Please ask for: Ms Iqraa Malik
Email: iqraa.malik@terraquest.co.uk
Telephone: 01212341390
Our Ref: AL/56/20/HH
Your Ref:
Date: 23rd July 2020

Application for Planning Permission for Works or Extension to a Dwelling

Development: Rear extension and ancillary buildings to existing dwelling
Location: Norton Dairy Old Dairy Lane Norton PO20 3AF

BLOCK PLAN - 1:500

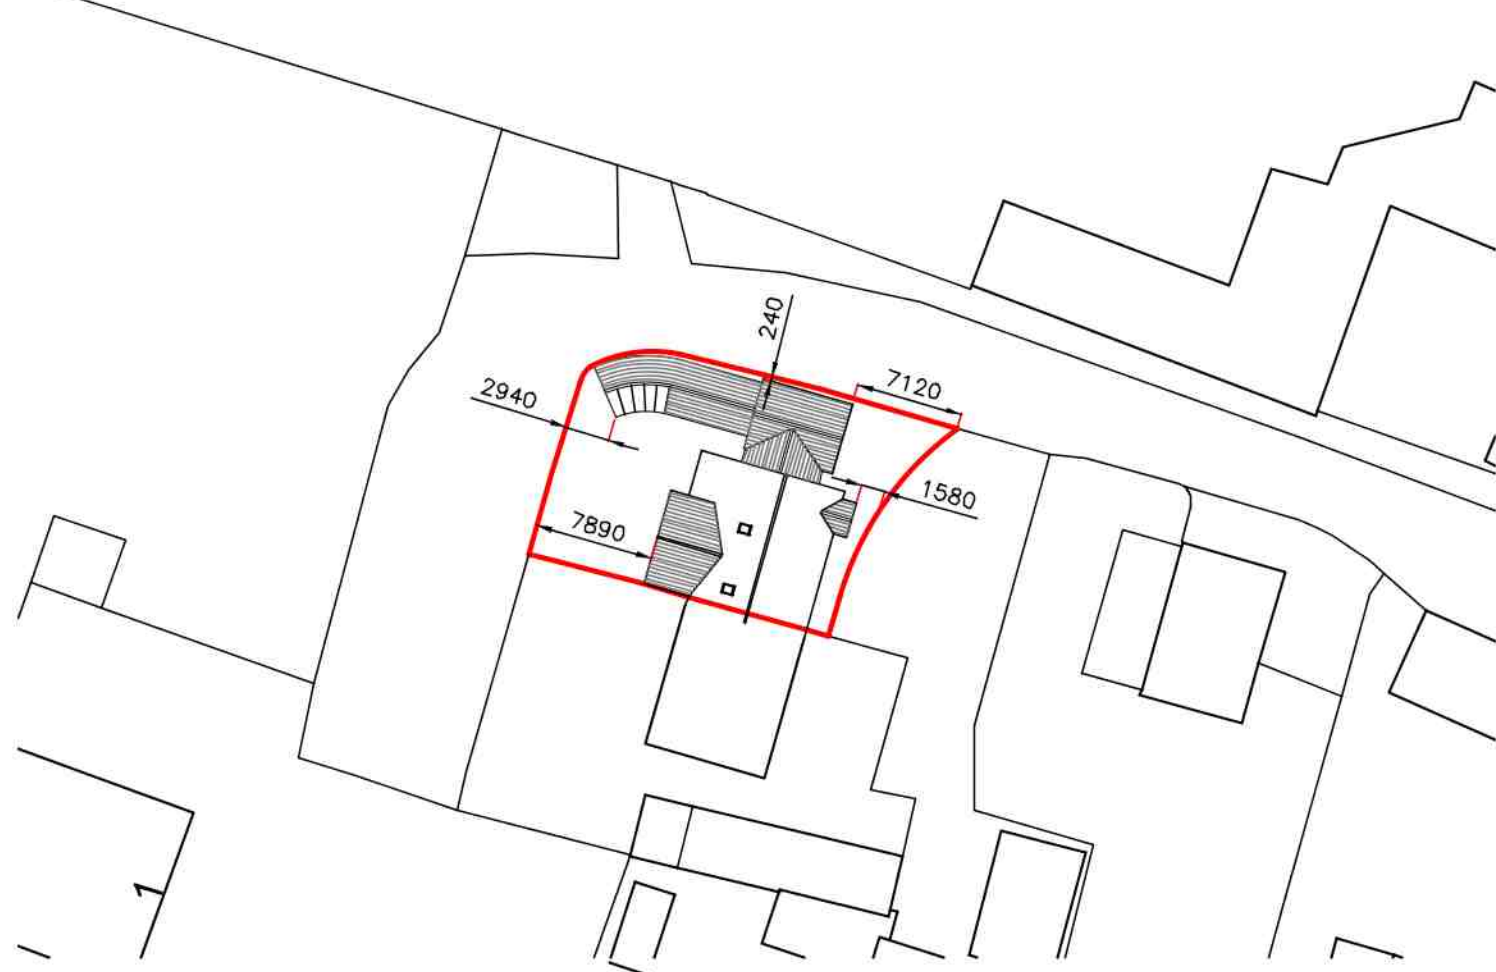
Block Plan

You are required to have dimensions from the proposed extension(s) to all site boundaries. Please amend.
